AB/76/20/L

55-57 High Street Arundel BN18 9AJ

Listed building consent for the conversion of existing mixed use space to 1 No one bedroom flat

Proposed Ground Floor Plan

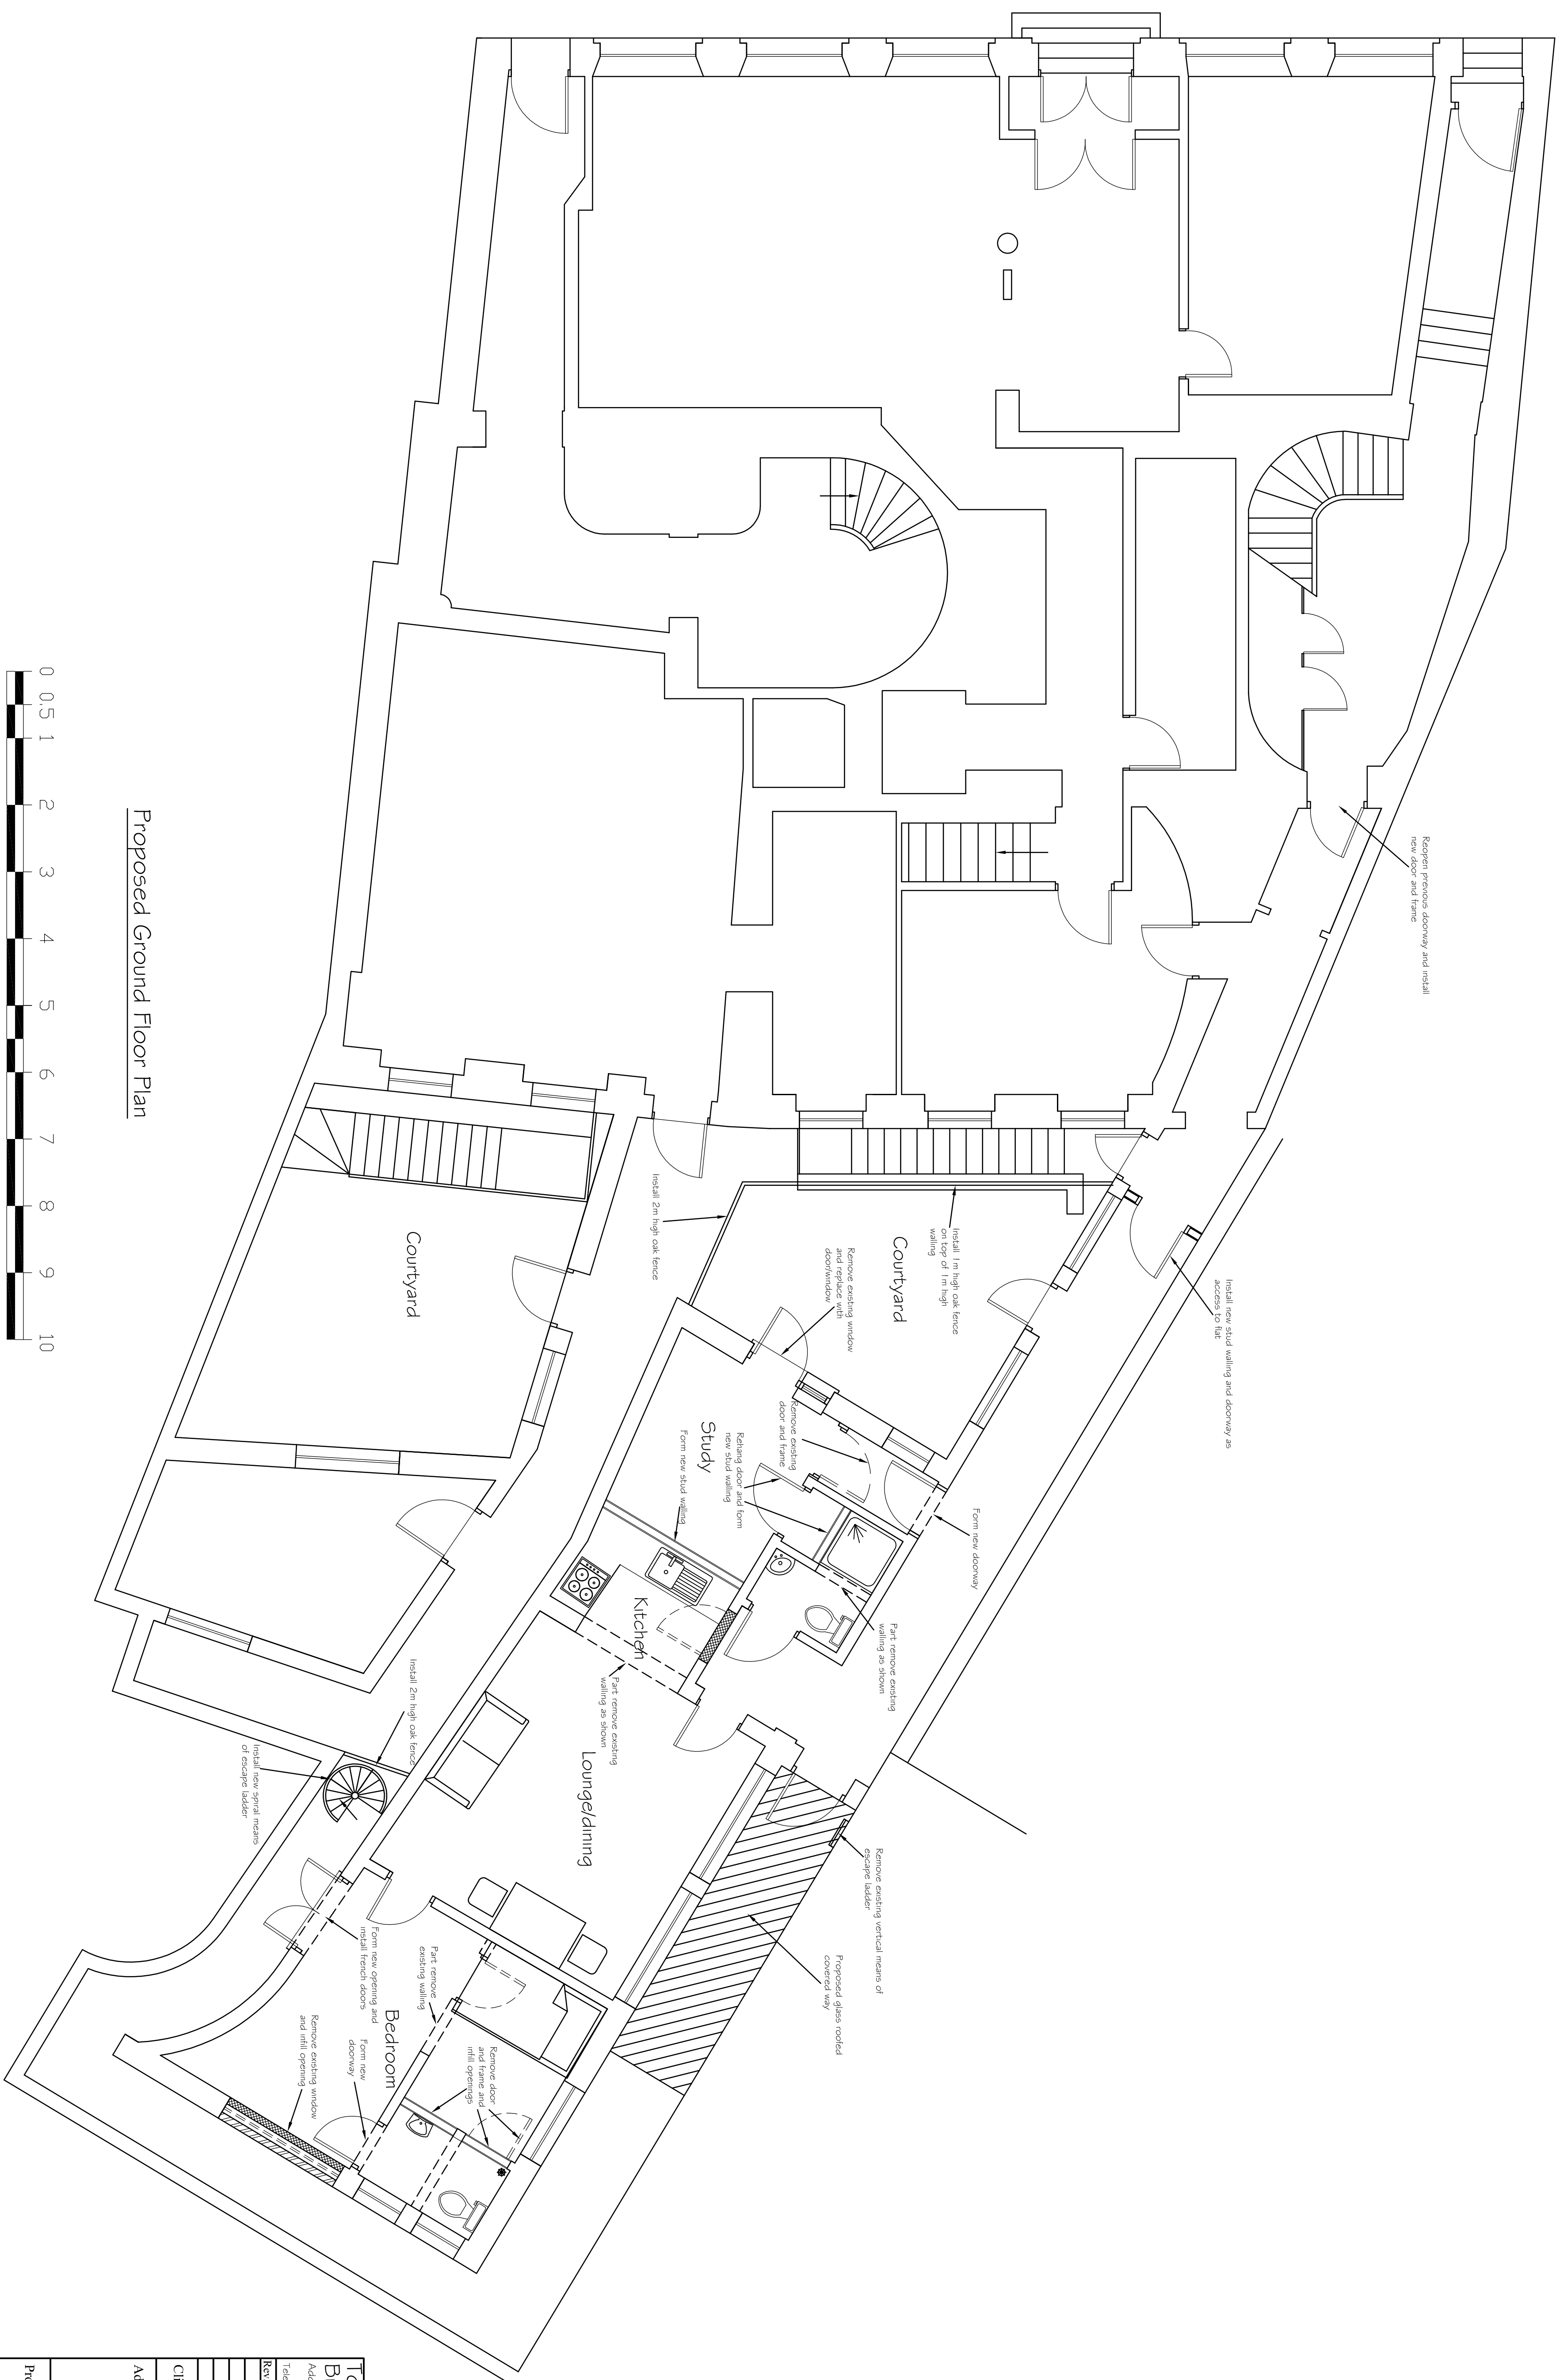
The proposed space requires a number of alterations to take place to this part of the building including internal works such as replacement ceiling, new internal stud walls and removal of part of existing walls. The existing Crittall windows will be retained and 12mm sealed glazed units inserted. Where new windows/doors are required, these will be of timber construction.

The proposal also requires the creation of a new opening within the hallway of number 55 High Street, in order to create a means of access to the new accommodation. I am aware that works have commenced without the appropriate permission/consent being granted.

I have been informed that there was previously an opening there, and that the current works are merely re-instating that opening – it would have helped if evidence to support this was supplied as part of the application. This opening relates to an attractive space behind which should not be harmed as part of the proposals.

If, this new opening is merely the re-opening of a previous doorway, the proposal should be acceptable. This is subject to details of the door and surround which should reflect the building.

Proposed Rear (West) Elevation

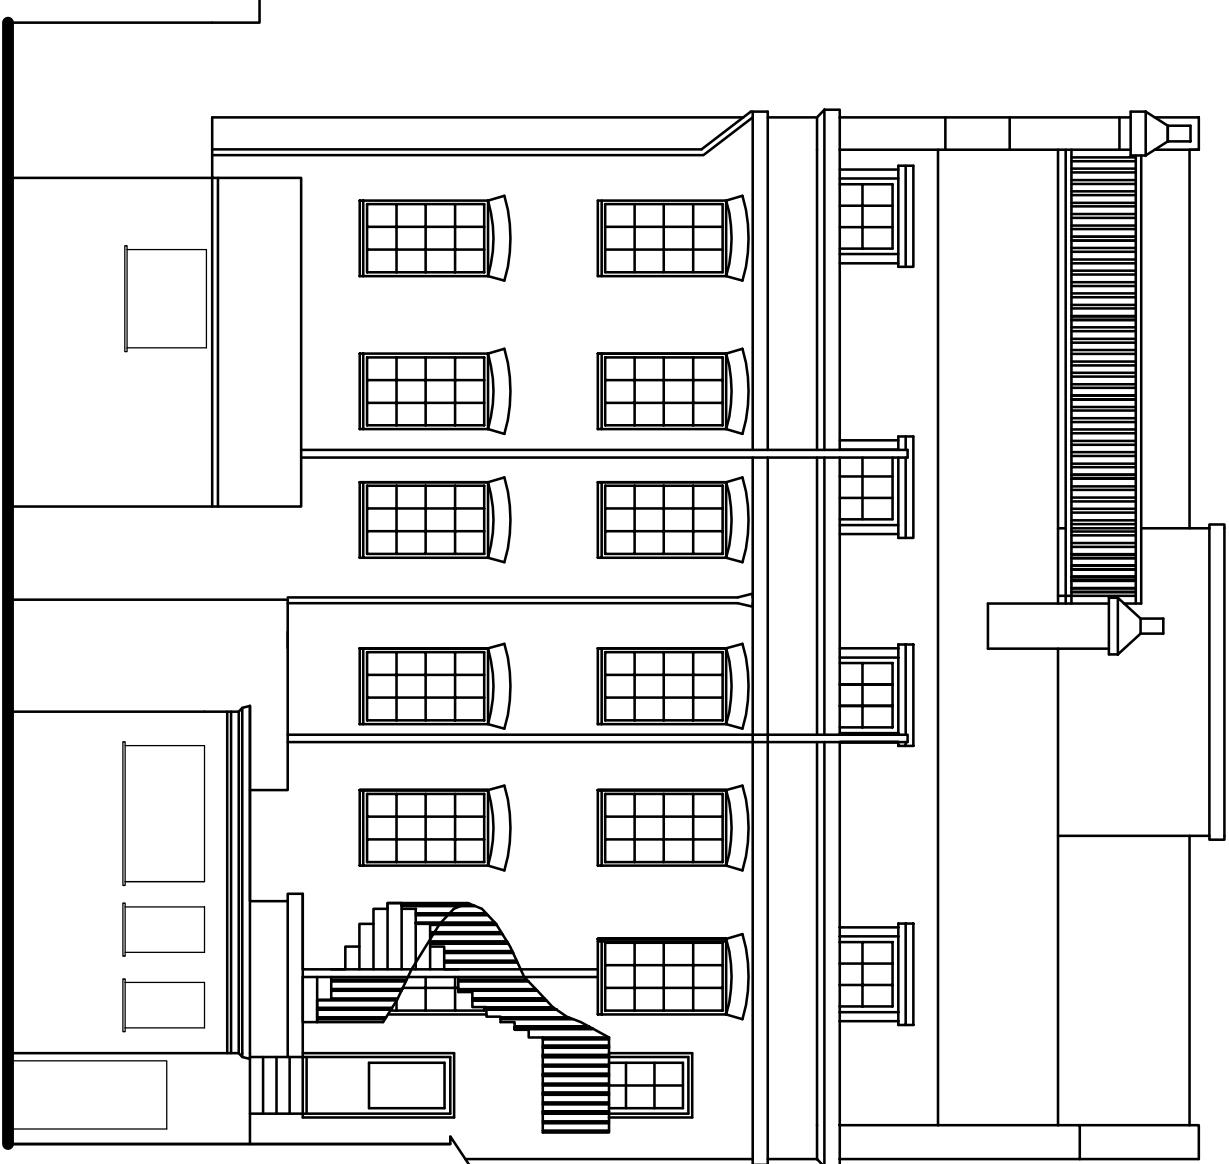
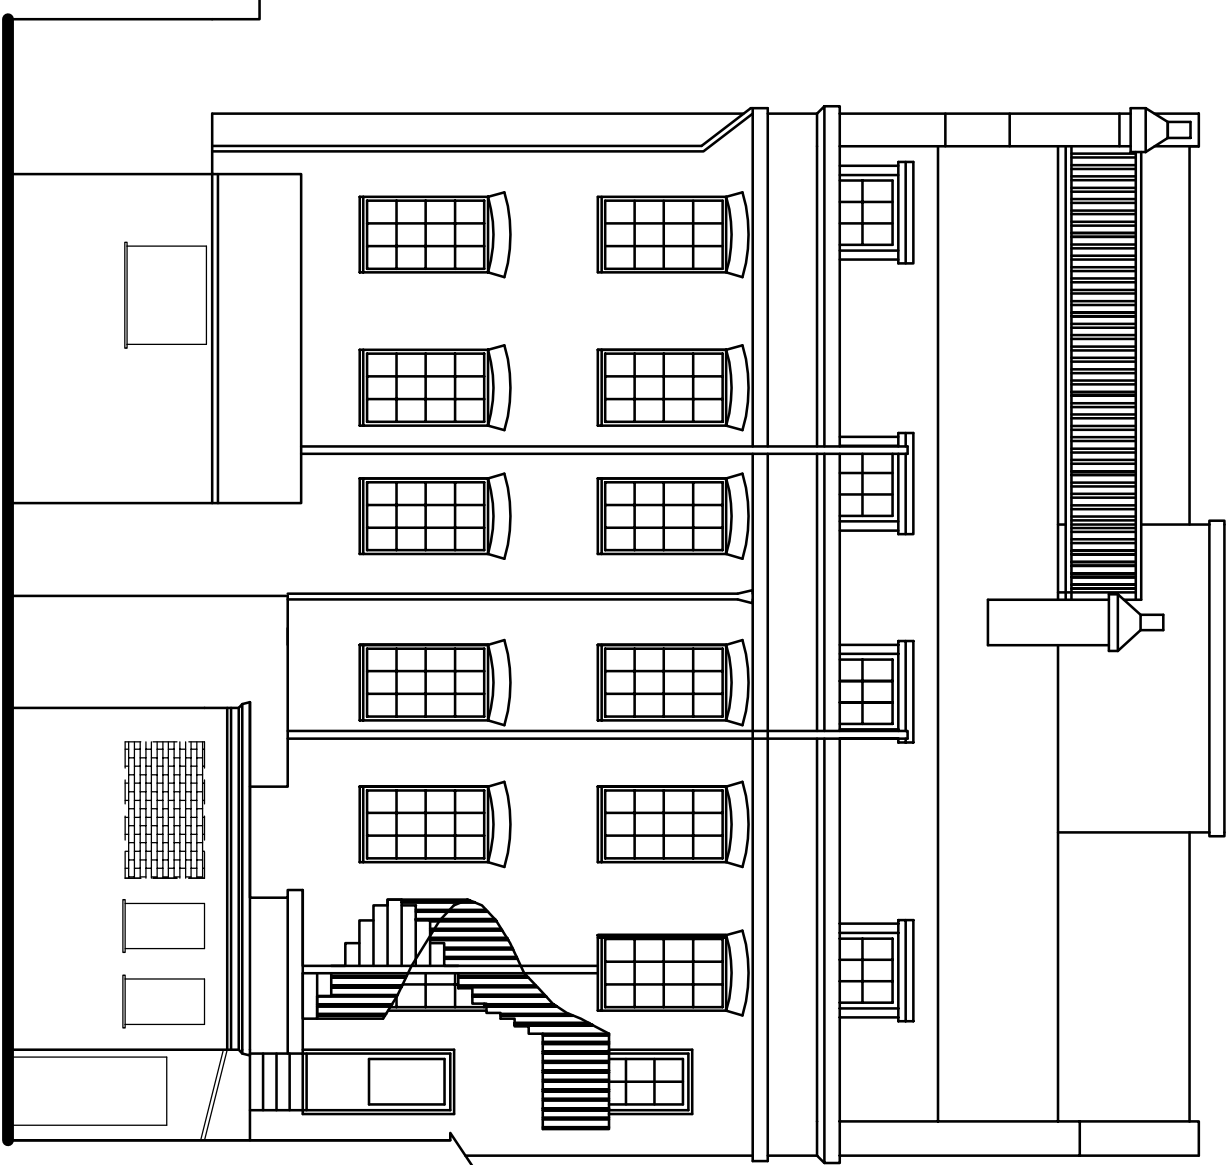
I also note that the proposal requires the removal of an existing vertical fire escape and its replacement with a new spiral staircase.

The use of timber windows/doors is supported as this material is appropriate for building and local area. However, I am unable to see any drawings of these new doors/windows. As a consequence, if you are minded to approve the application details of the windows/doors should be submitted to the LPA by way of condition.

Of concern is the introduction of fencing which will provide some form of private amenity space to the new accommodation. This is in close proximity to another part of the building which will influence how part of the rear elevation of the townhouse is viewed. Whilst its reason is understood, it is not an ideal solution. It is also not entirely clear what this will look like, and if you are minded to approve the application, further details are required. This will include their appearance and any treatment/any colours.
